ENG-CDR21014-R3-CDs.pdf Markup Summary

Subject: Callout
Page Index: 1
Date: 4/29/2022 3:53:05 PM
Author: dsdrice
Color: ■
Layer:
Space:
Page Label: [1] 1 COVER SHEET

DROP STRUCTURE  
DETAILS (#4, #5, #6, #7, #8,  
#9, #10)

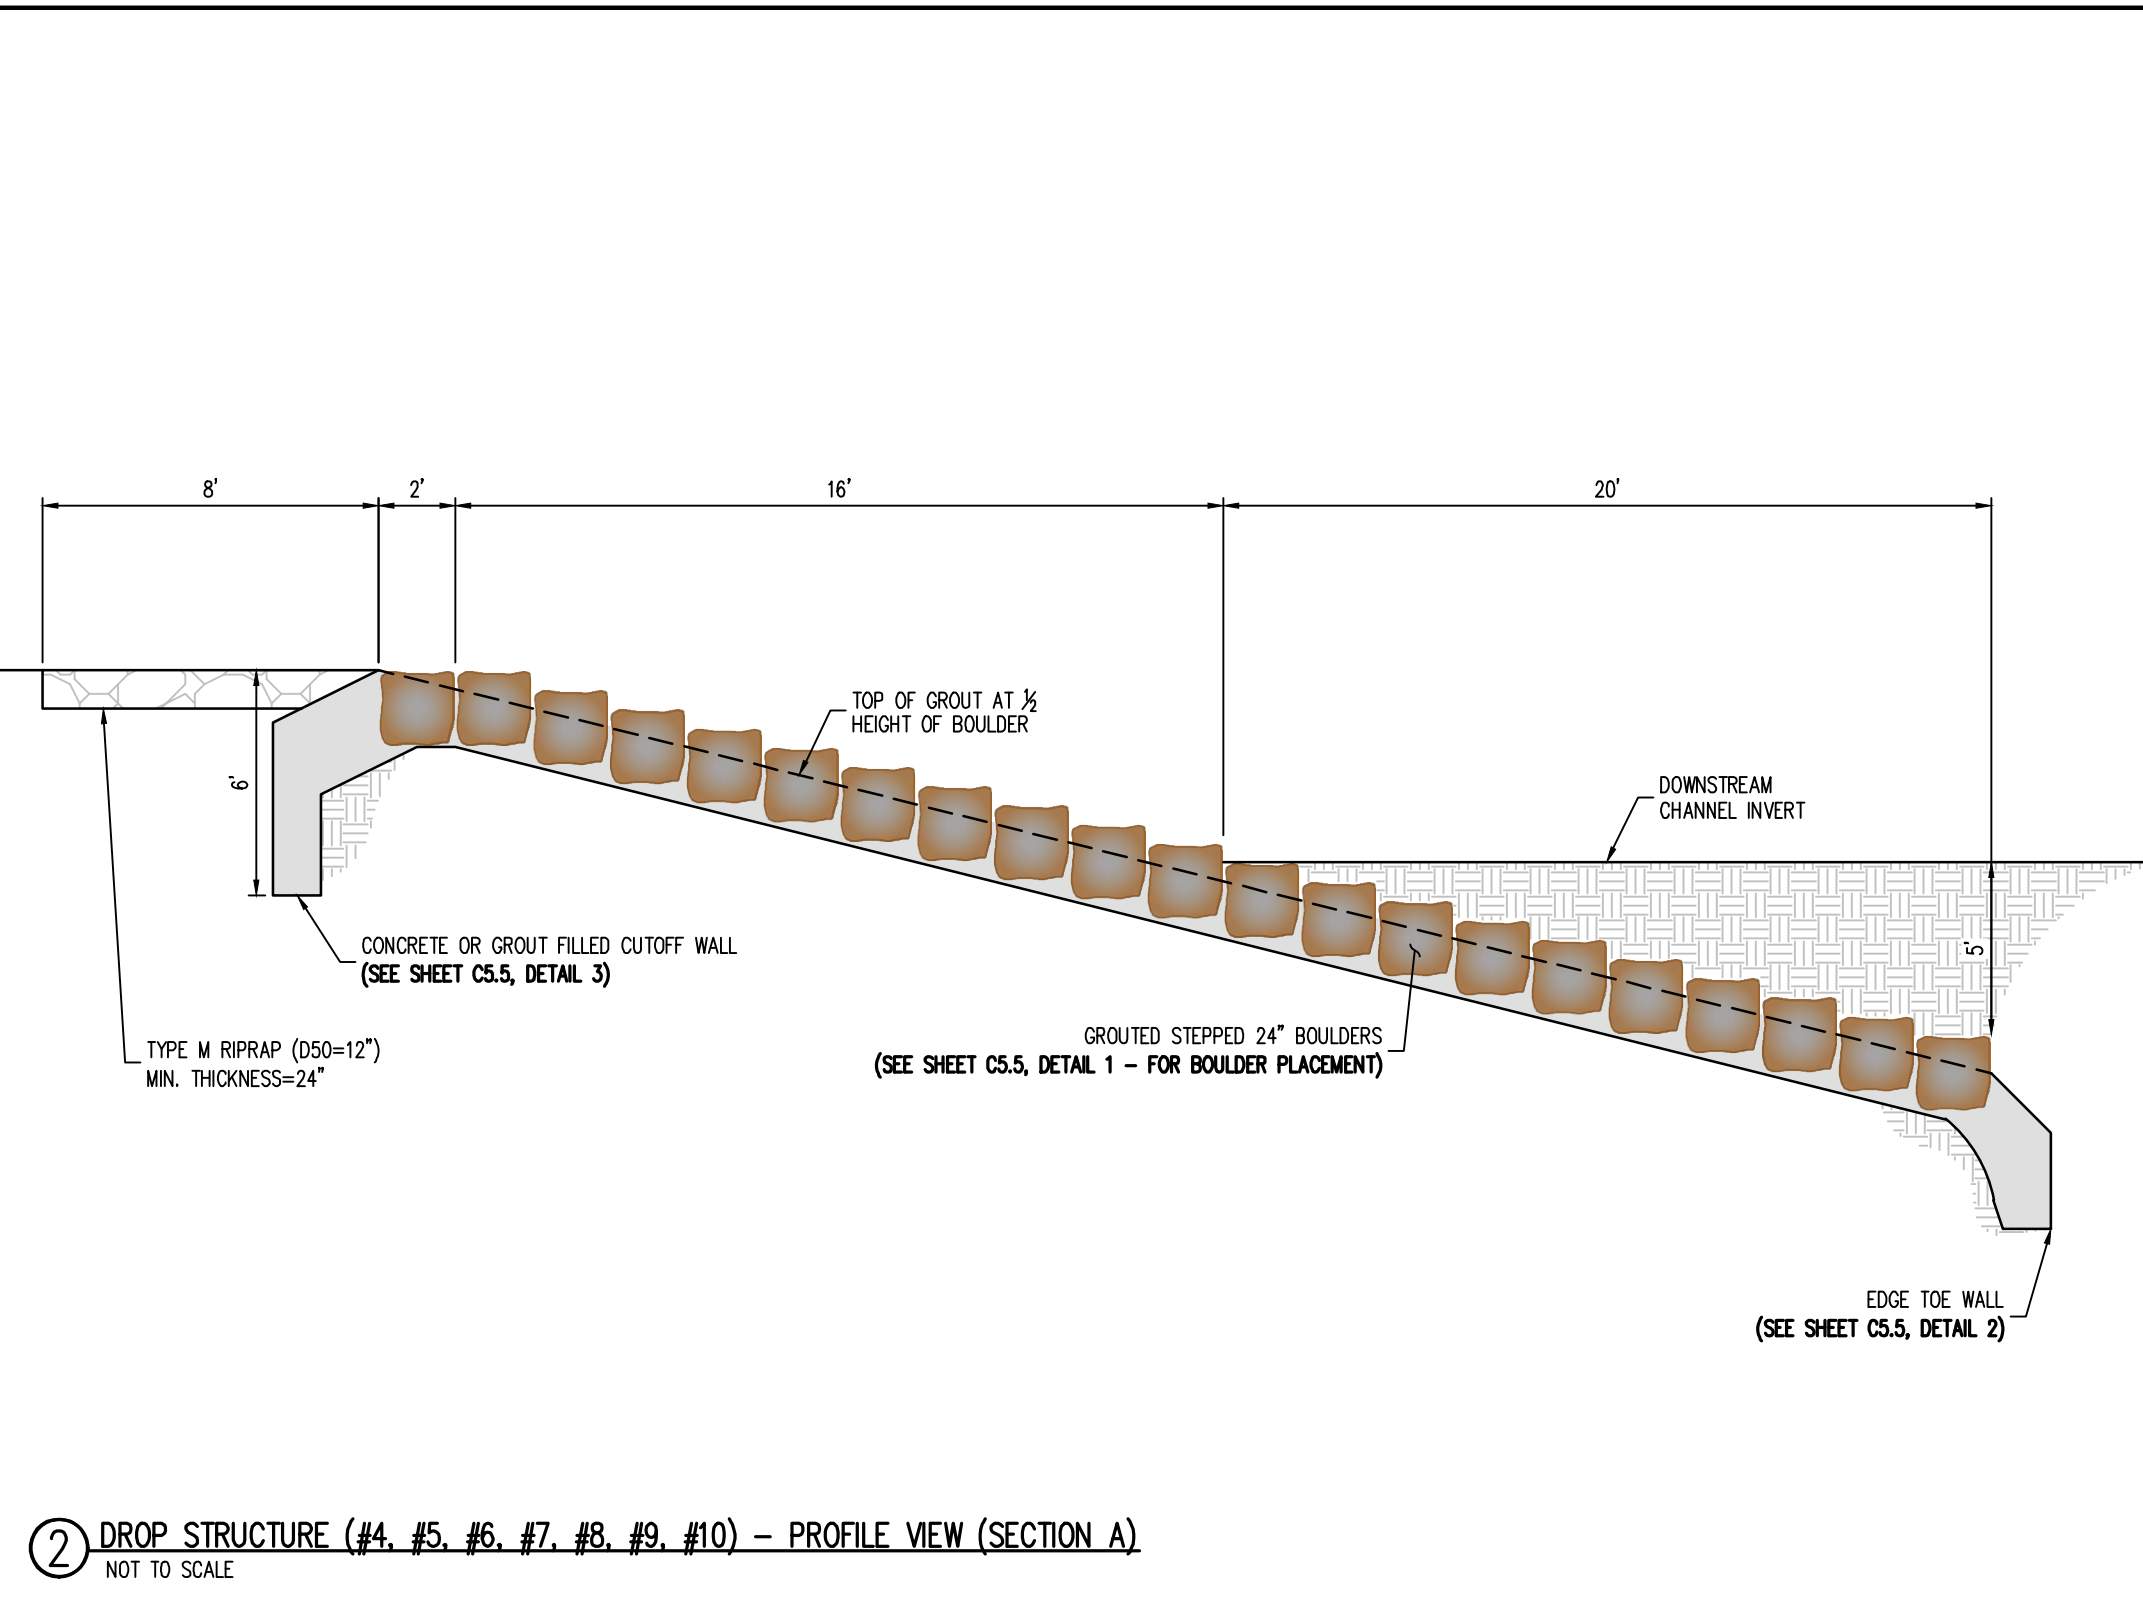
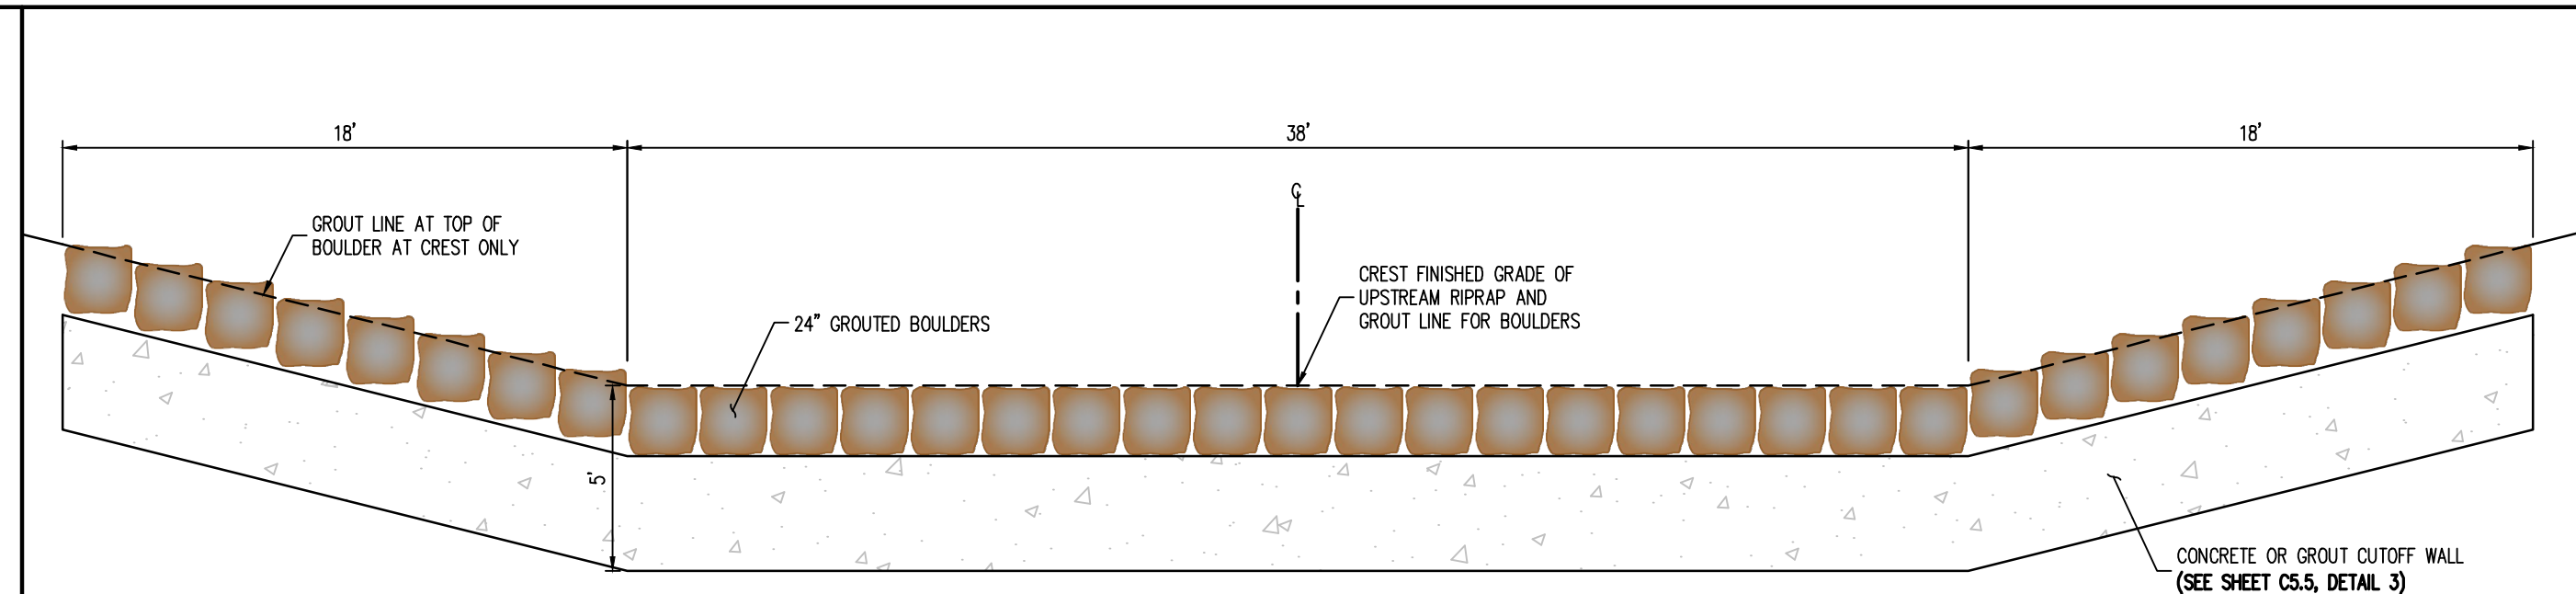
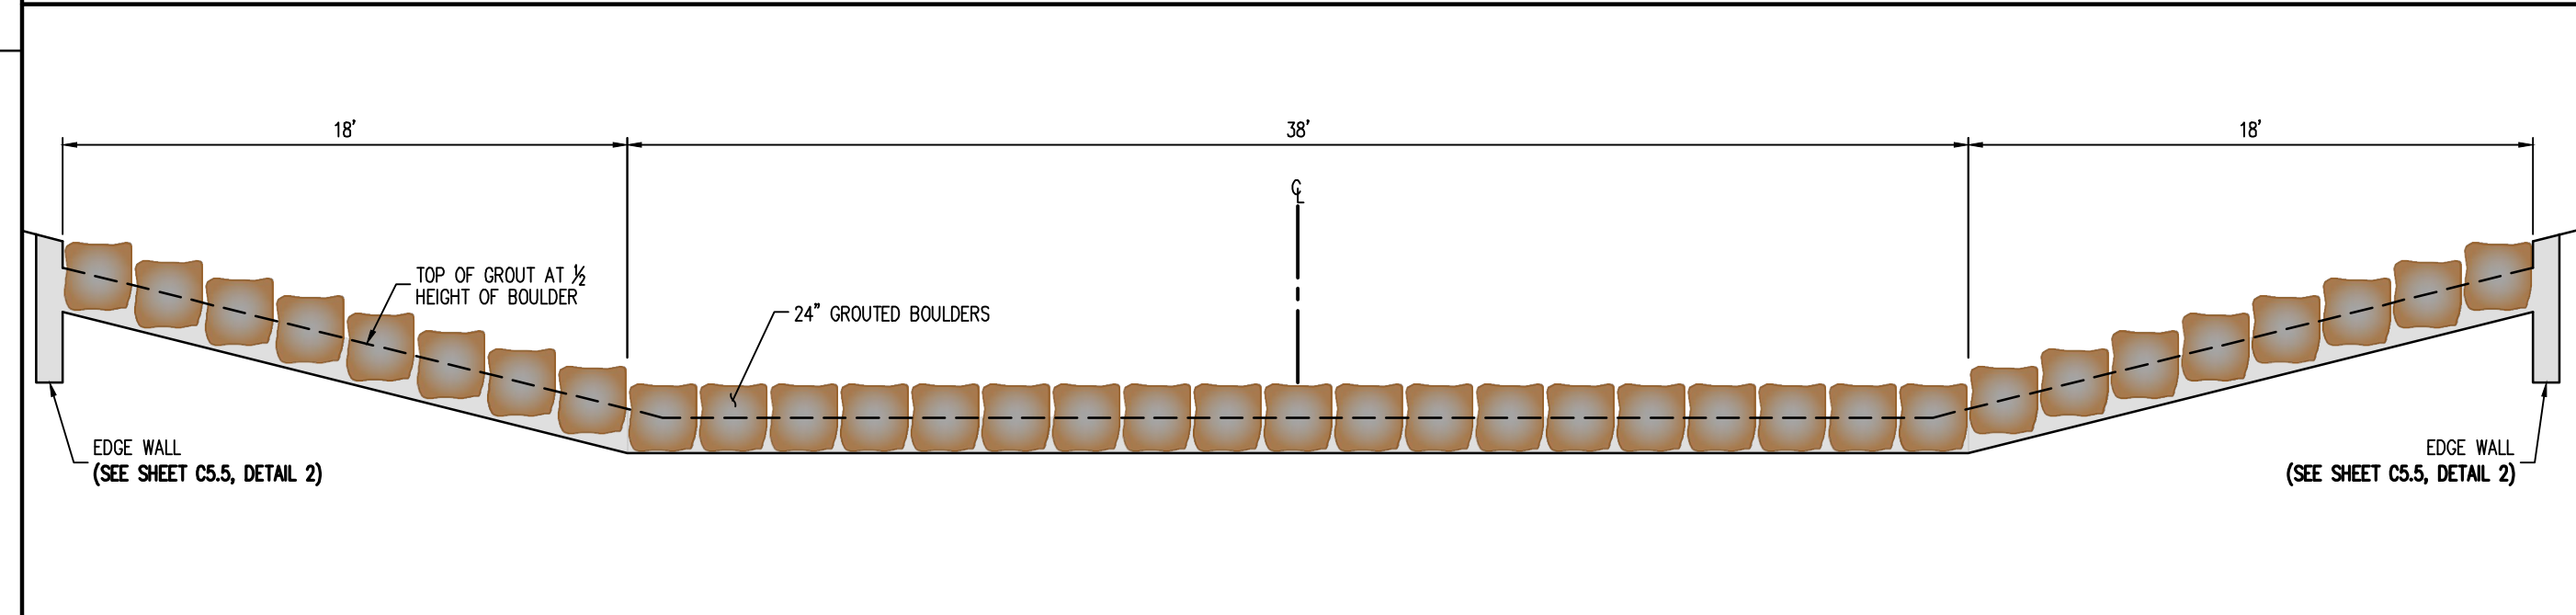
Do you want to highlight these areas?
